13 July 2017

Re Planning Application A/87/17/HH The Old cottage, Station Road, Angmering

PROPOSED FLOOR PLANS 1:50

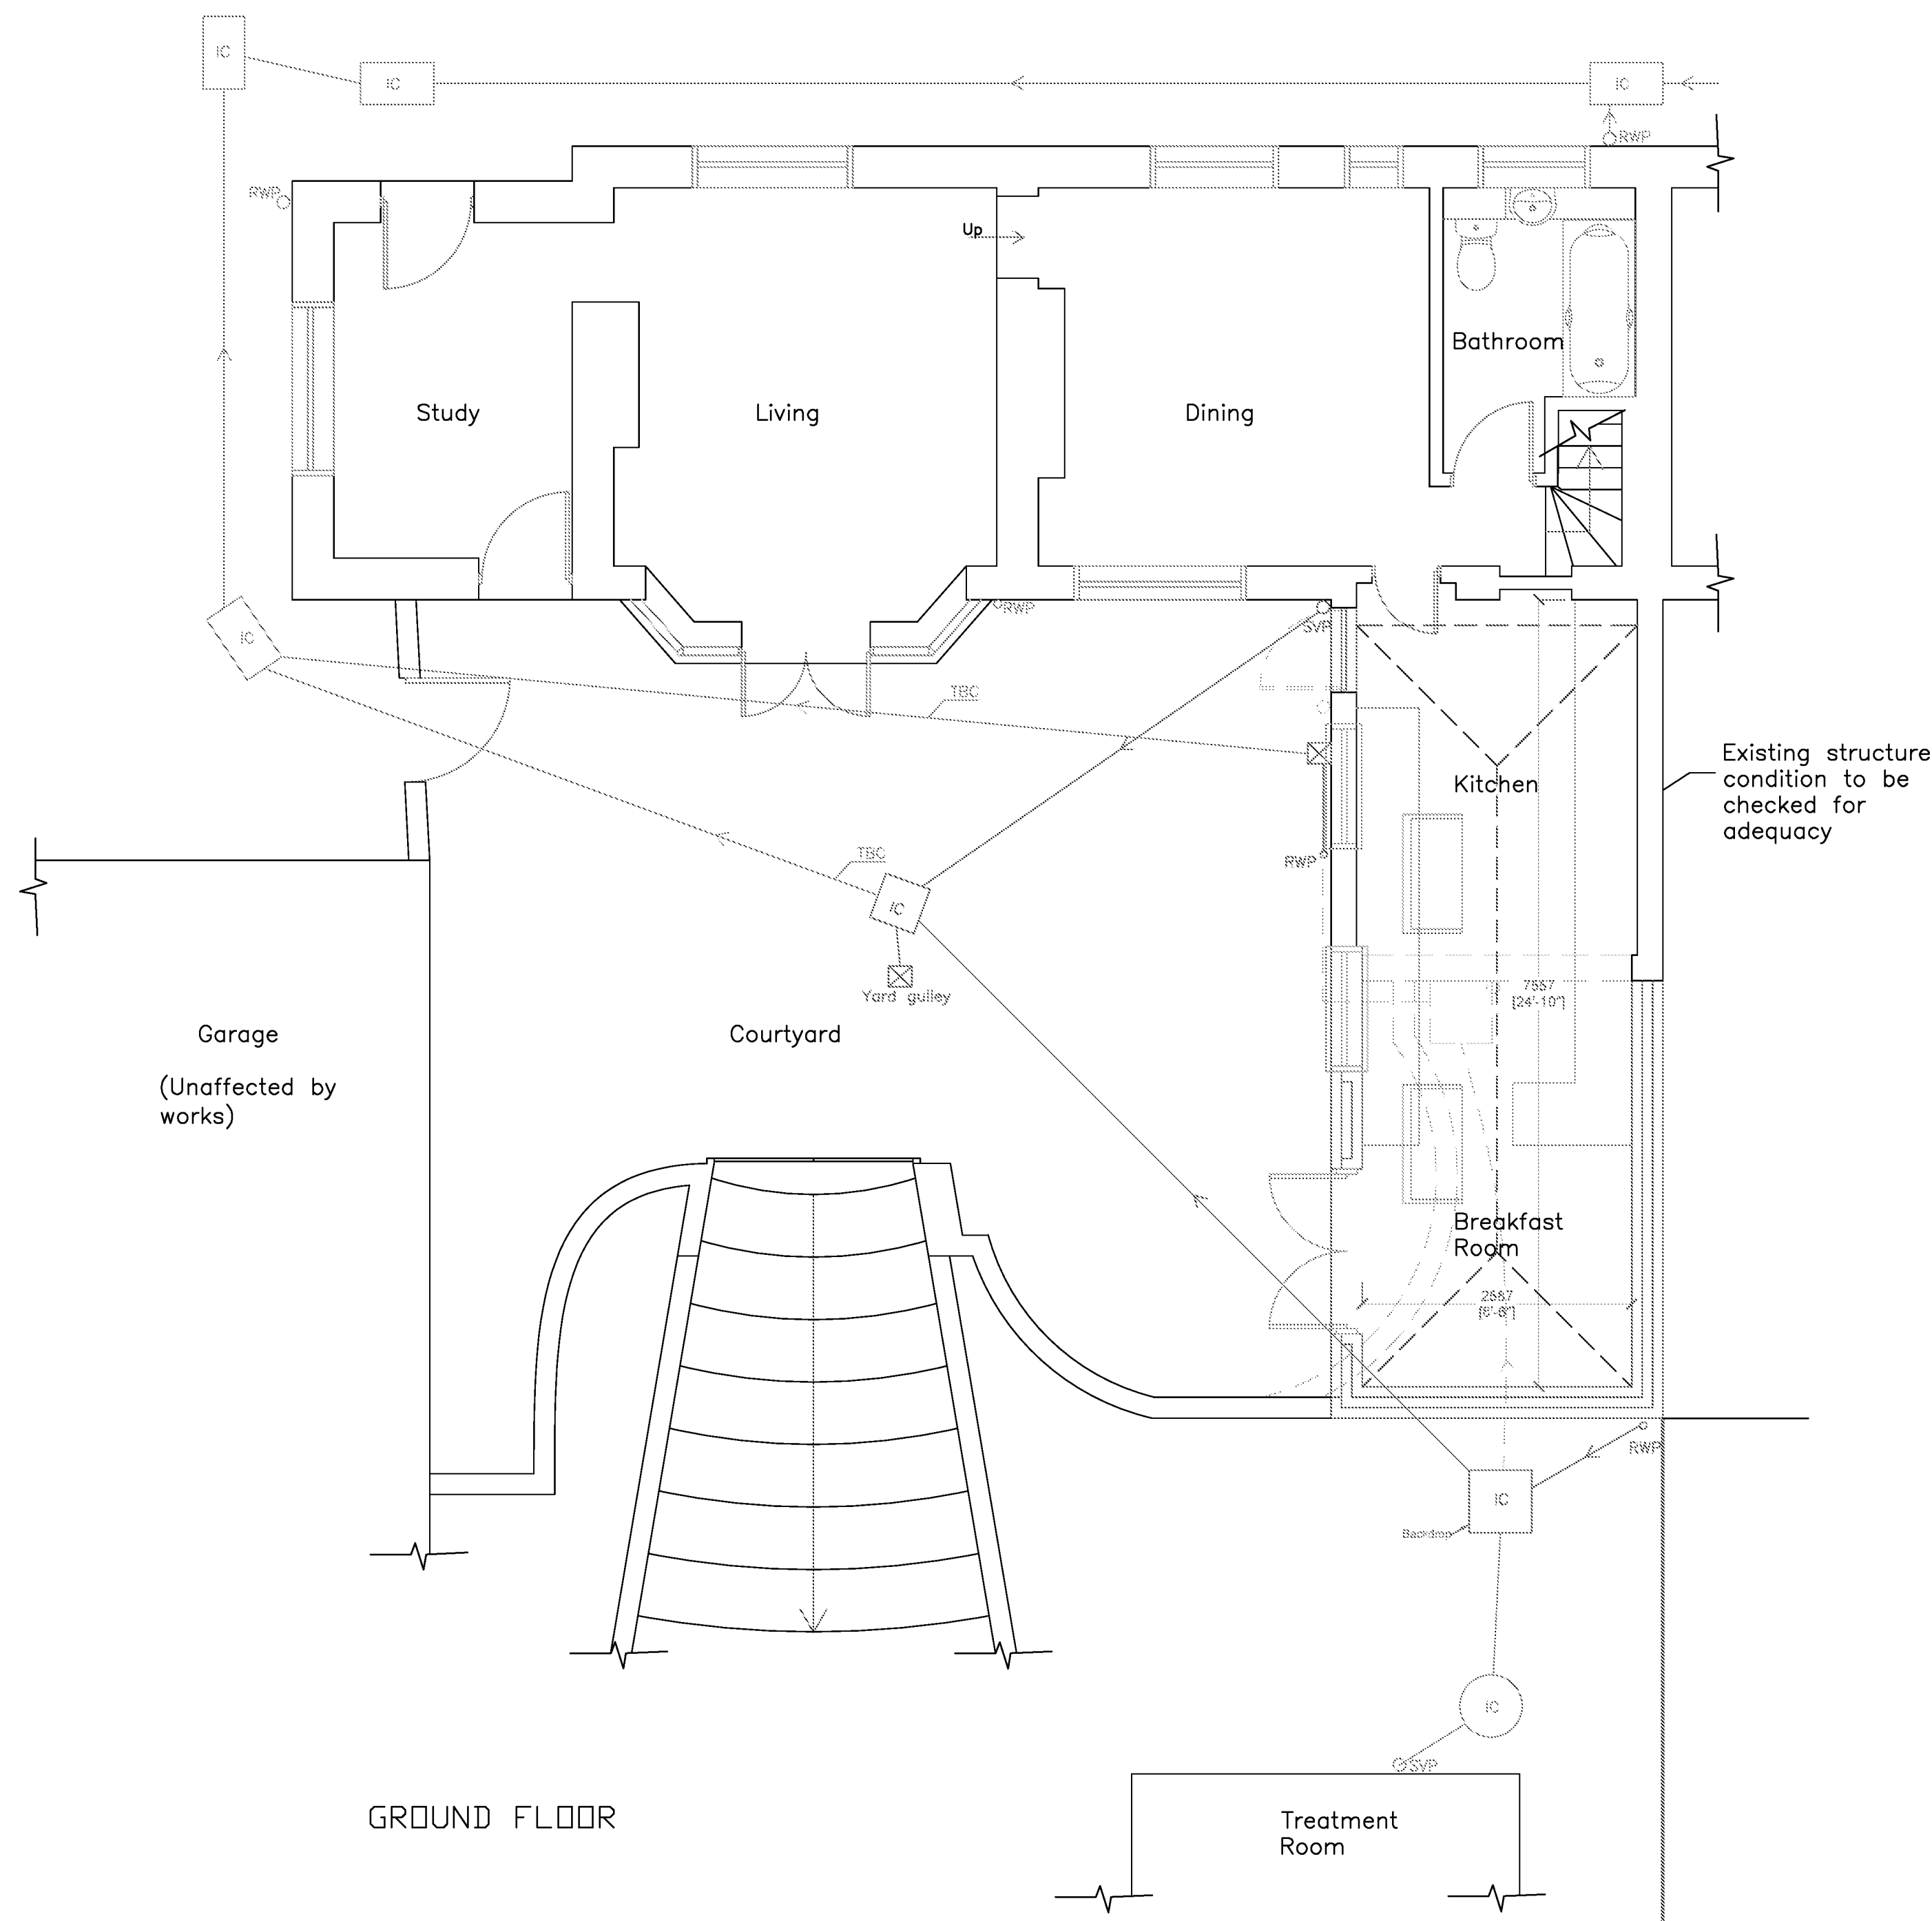
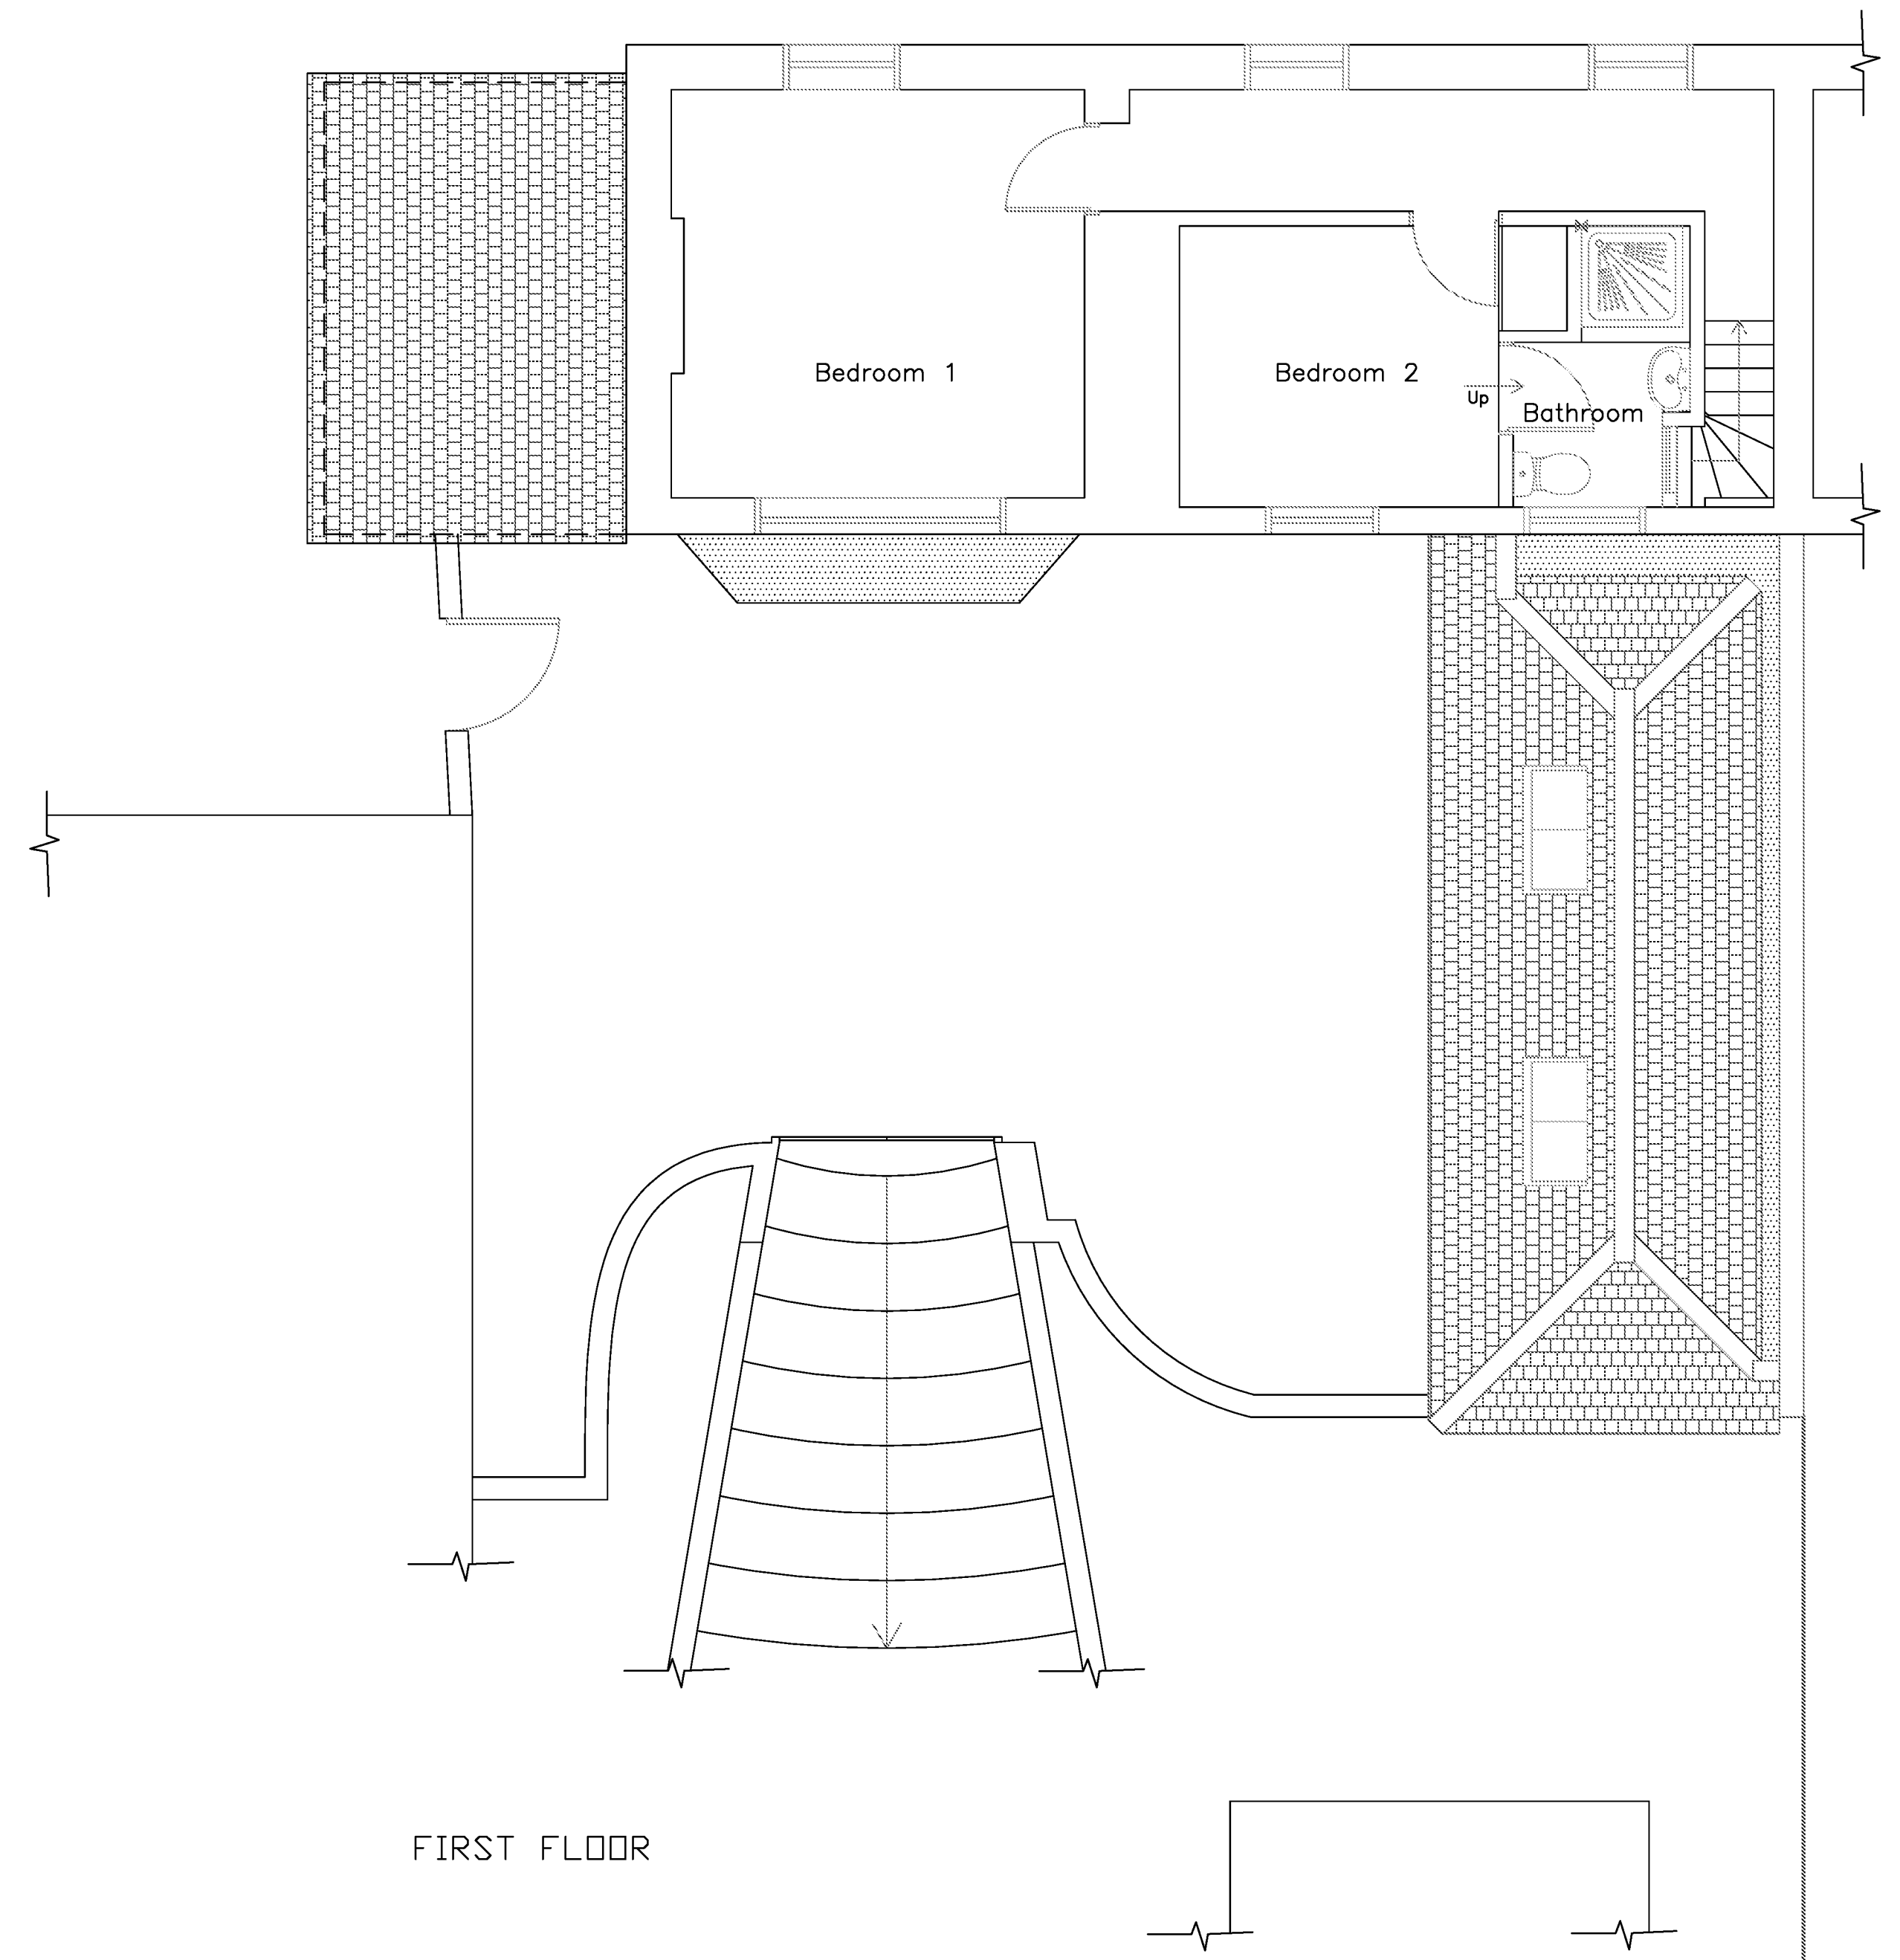
Furthermore, should the Hinds get permission to build this extension it deeply affects my mothers house next door – the current outside wall of his extension kitchen is right outside my mothers kitchen window and conservatory and is a party wall. The flat roof of the existing extension is directly under my mothers bedroom window and to put a pitched roof on this extension (and the extension to the extension which he is

planning) would gravely alter the look of the back of these properties and is out of keeping with line of the building, and the appearance and character of a beautiful thatched seventeenth century grade 2 listed building.
